WEST SUSSEX COUNTY COUNCIL CONSULTATION

TO:	Arun District Council FAO:Amber Willard
FROM:	WSCC - Highways Authority
DATE:	10 February 2022
LOCATION:	Land to the rear of 27 Station Road Bognor Regis PO21 1QD
SUBJECT:	BR/283/21/PD Notification for Prior Approval under Schedule 2 Part 3 Class MA for the Change of Use from Commercial, Business and Services (Use Class E) to Dwellinghouse (Use Class C3).
DATE OF SITE VISIT:	n/a
RECOMMENDATION:	Advice
S106 CONTRIBUTION TOTAL:	n/a

BLOCK PLAN
Sc. 1:500

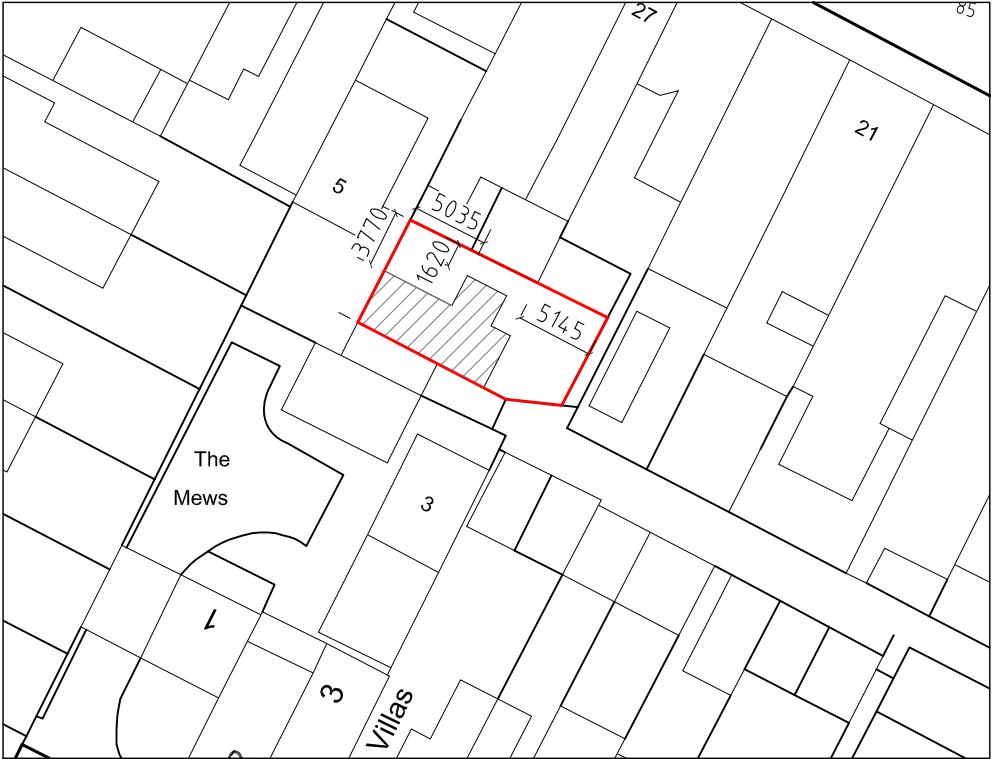
This application provides parking provision for 1 vehicle, accessed via a rear access way, off of Crescent Road, a C-classified road subject to a speed limit of 30mph. However the LHA note that the width of the access way is approximately 2.1m at the back edge of the footway, with brick walls either side. As such, the LHA would question whether this access road is of sufficient width to enable a vehicle to enter and exit onto the public highway. As such, the LHA would be minded to consider that the proposed parking space is inaccessible and therefore the proposed dwelling should be treated as having a nil parking provision. The WSCC Parking Demand Calculator expects that one space would be required for a dwelling of this size and location.

If the Local Planning Authority is minded to approve the application, they may wish to condition cycle parking.
